**From:** Oliver Brown [REDACTED]  
**Sent:** 14 June 2012 18:01  
**To:** Anita Gardner  
**Subject:** Re: R/99/12 Amendments to existing dwelling and new boundary walling - 1 Botany Close, Rustington  
**Attachments:** 0293(01)06,09-10 Proposed Elevations .pdf; ATT00001.htm; 0293(01)14-16 Existing and Proposed Boundary Wall .pdf; ATT00002.htm

Proposed Front Elevation
(Street View)

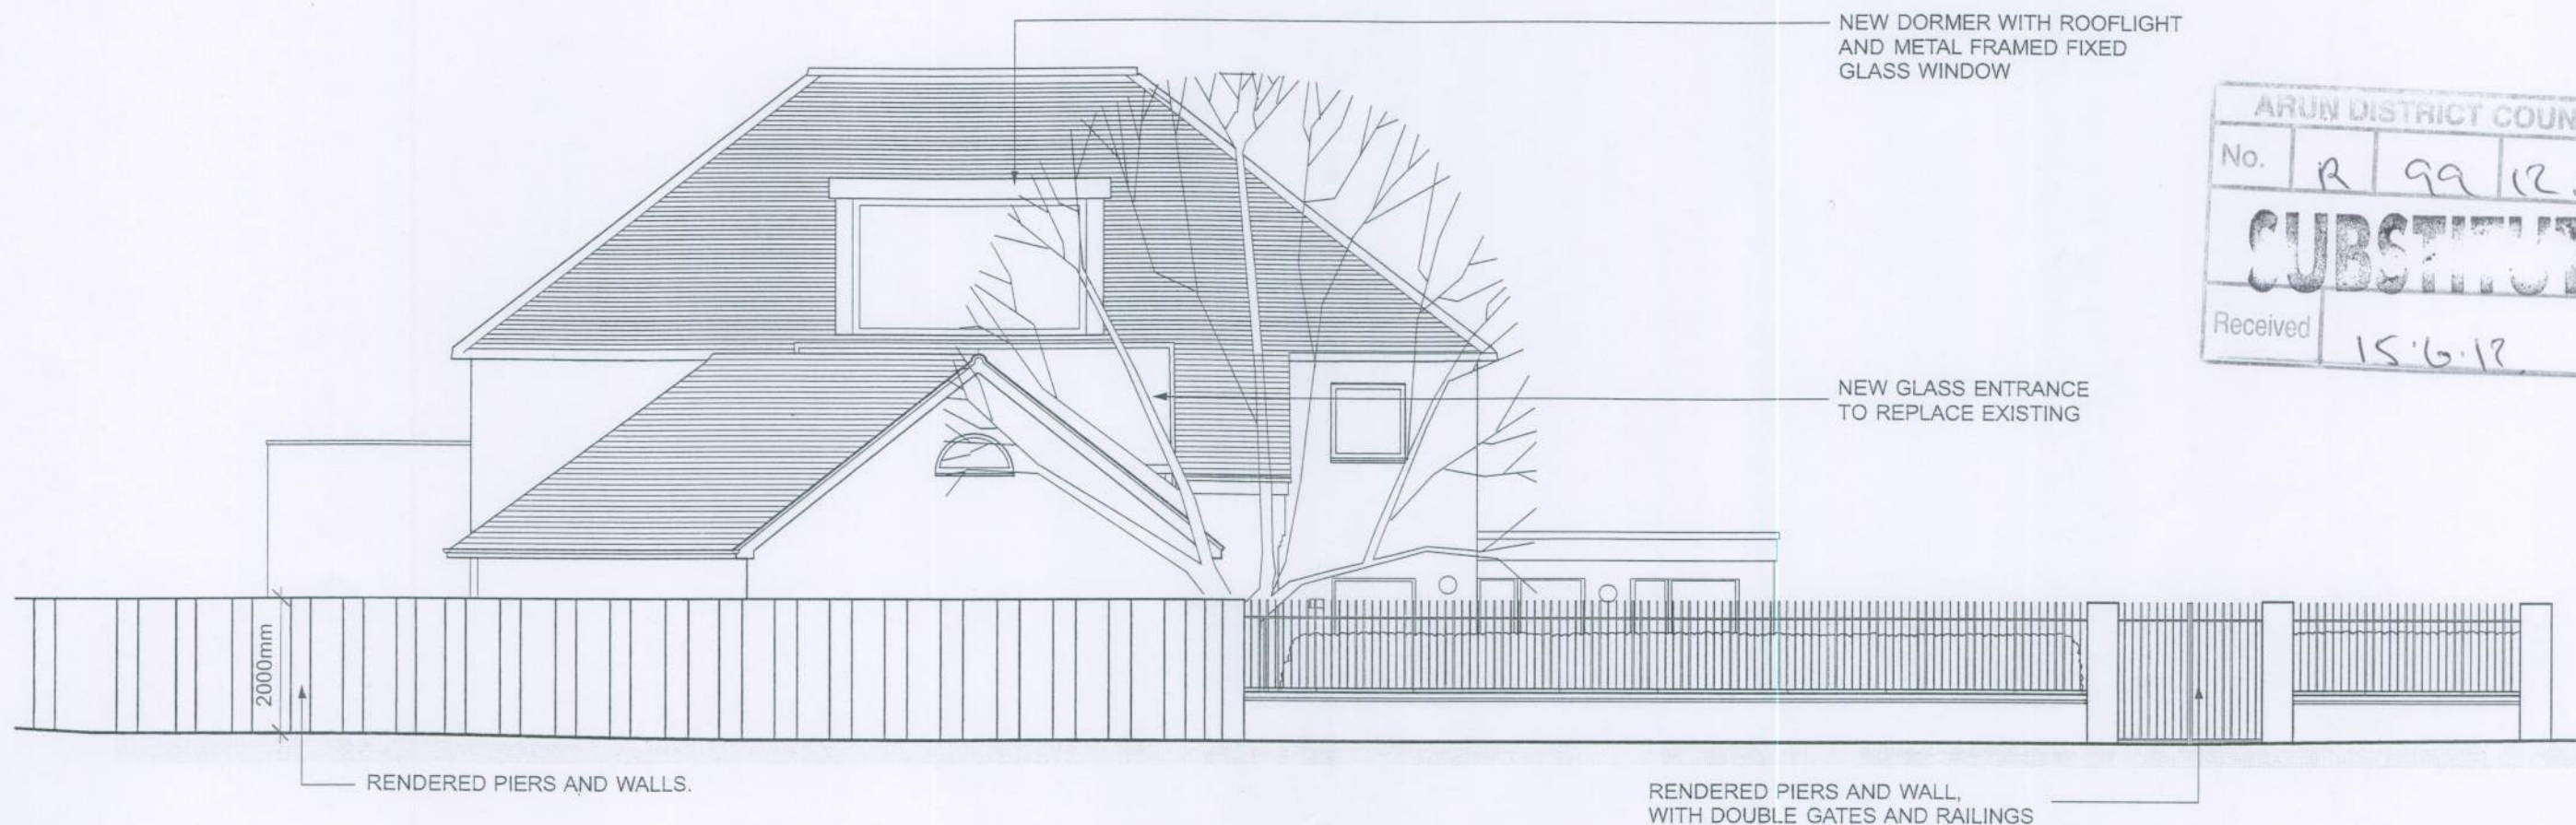
Further to my telephone message earlier today please see attached proposed elevations with amendments to the boundary walls to a white rendered finish with piers, as opposed to brick facing.
